Please ask for: Mrs D Johnson
Email: daun.johnson@arun.gov.uk
Telephone: 01903 737762
Our Ref: AL/12/25/PL
Your Ref:
Date: 11th February 2025

Application for Planning Permission

Development: New permanent building to improve the current water treatment facilities with the construction of a new PRV building. This application is in CIL zone 3 (Zero Rated) as other development.
Location: Portsmouth Water Westergate Wtw Level Mare Lane Westergate PO20 3SB

- Finish = Semi-gloss
- Colour = 14C39 Empire Green

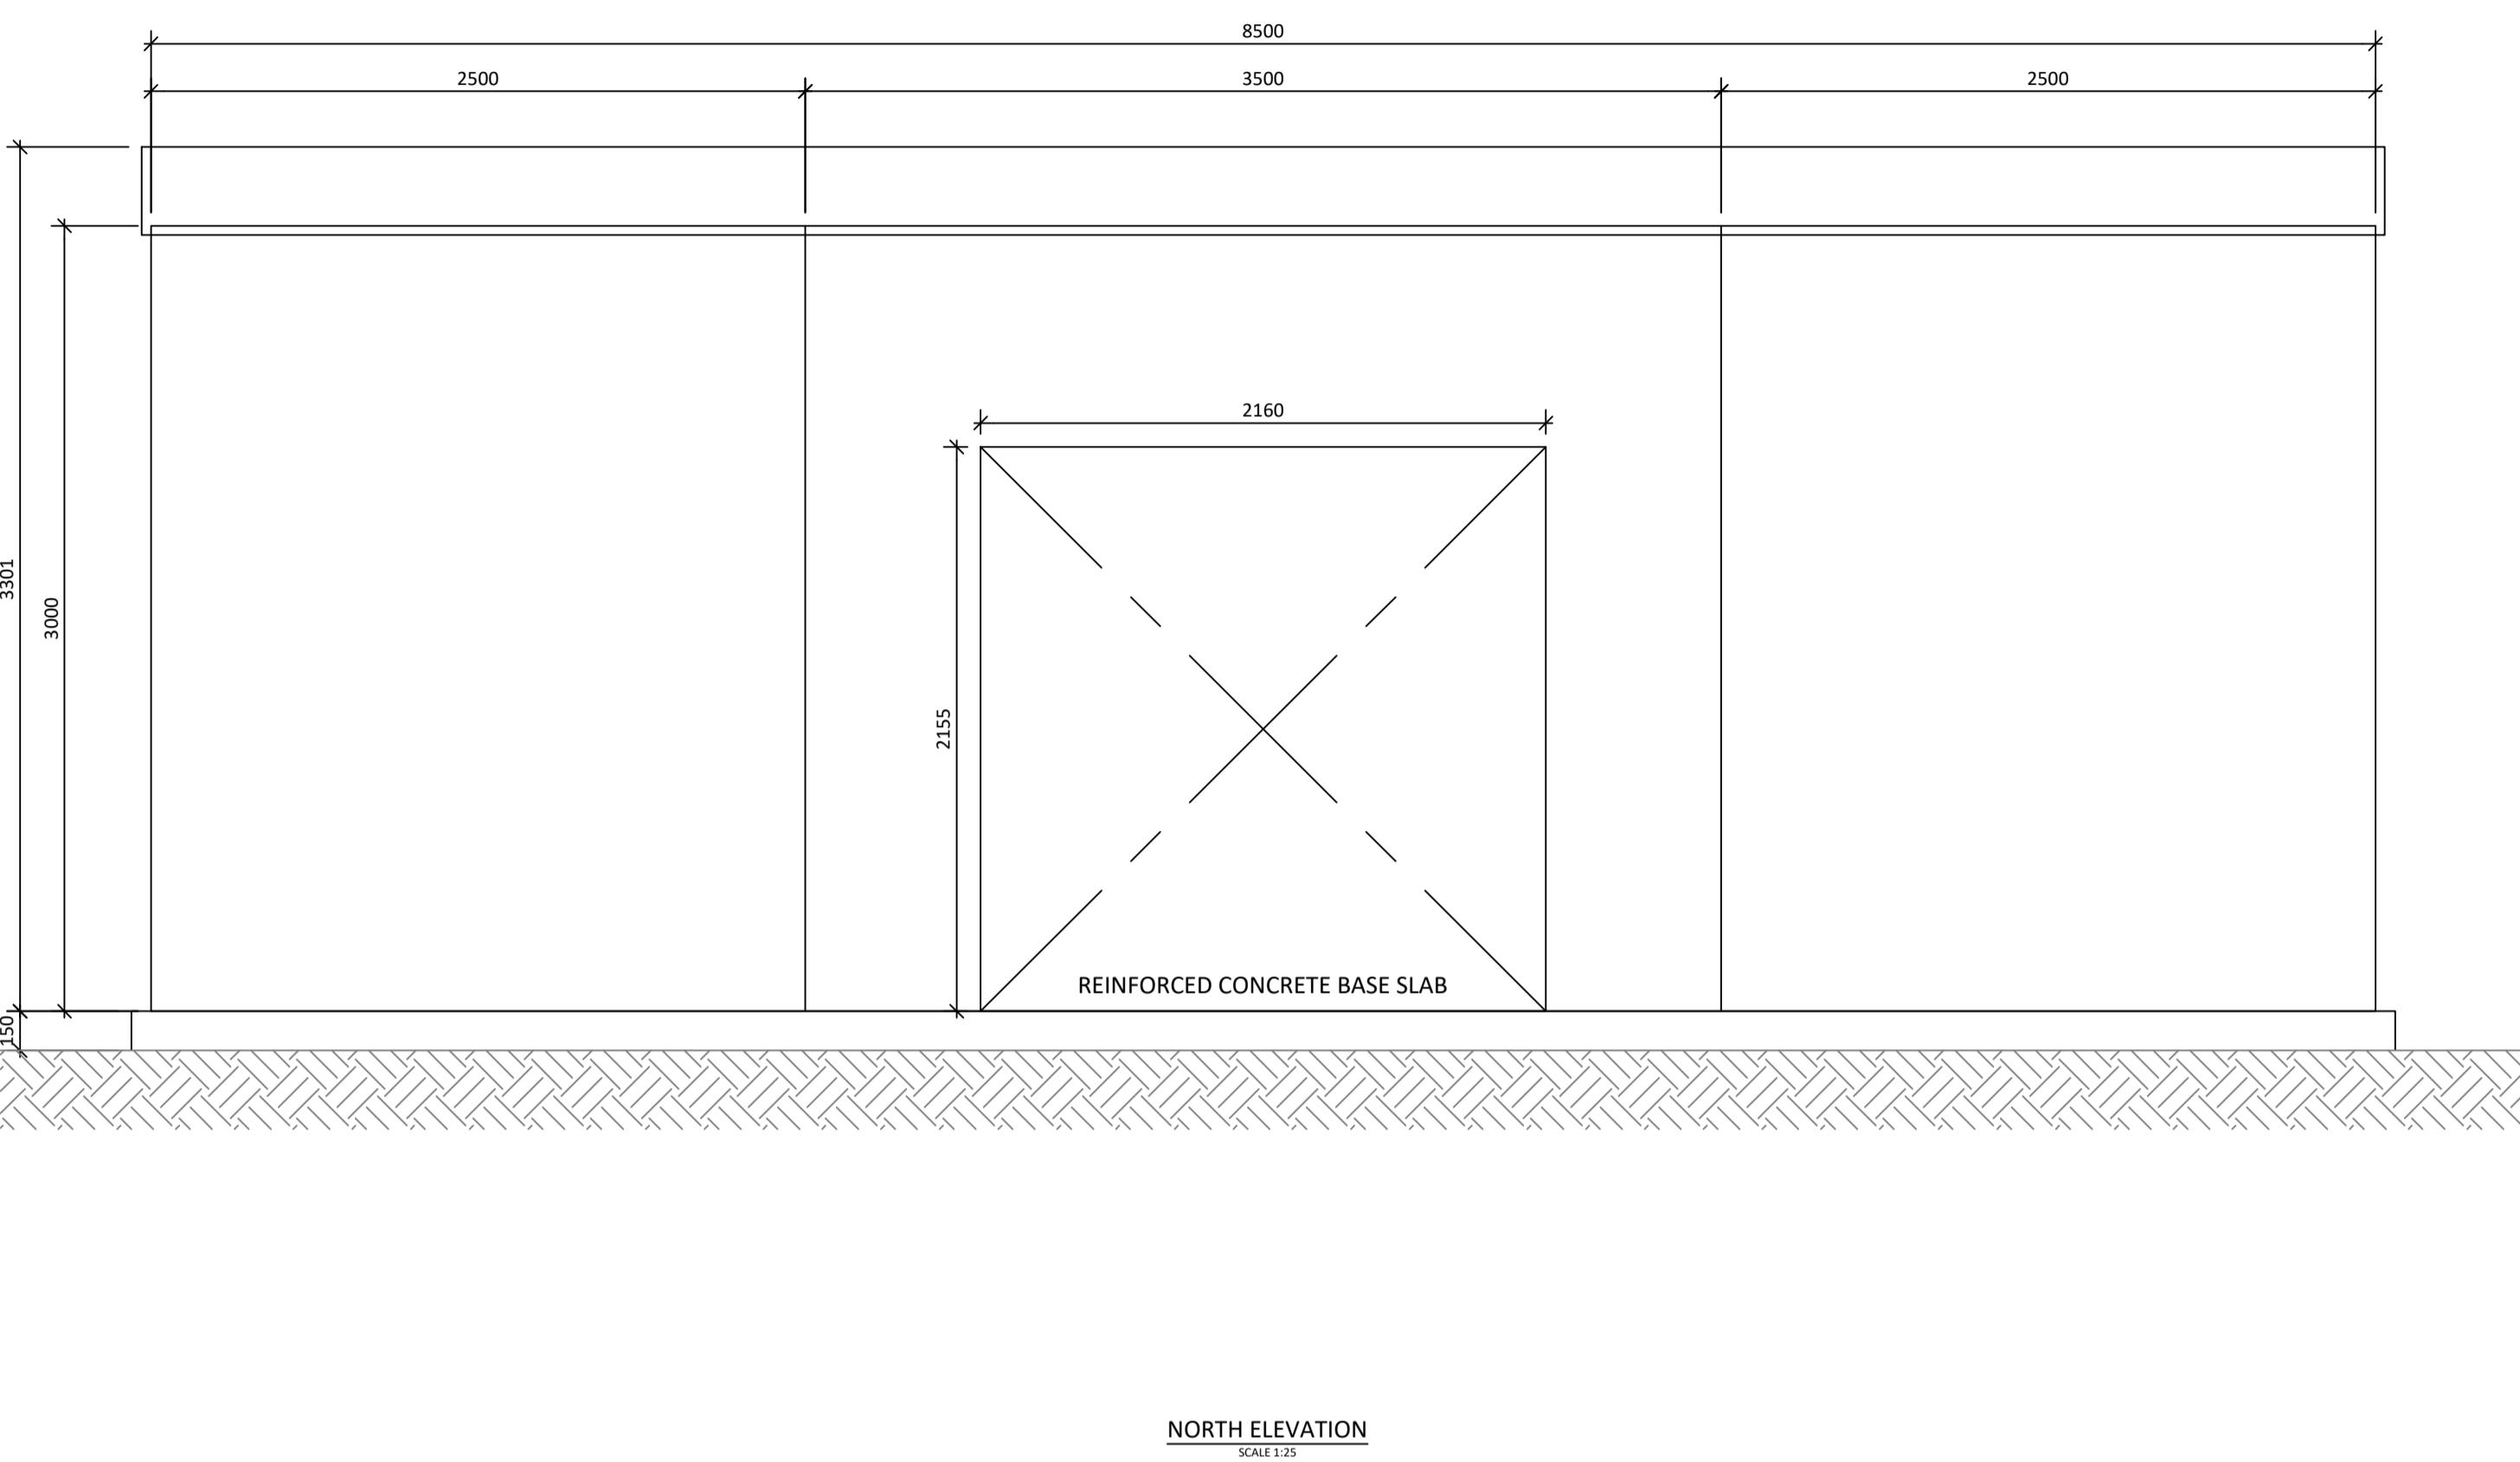
The floor plan and elevations do not scale correctly. Please amend accordingly.
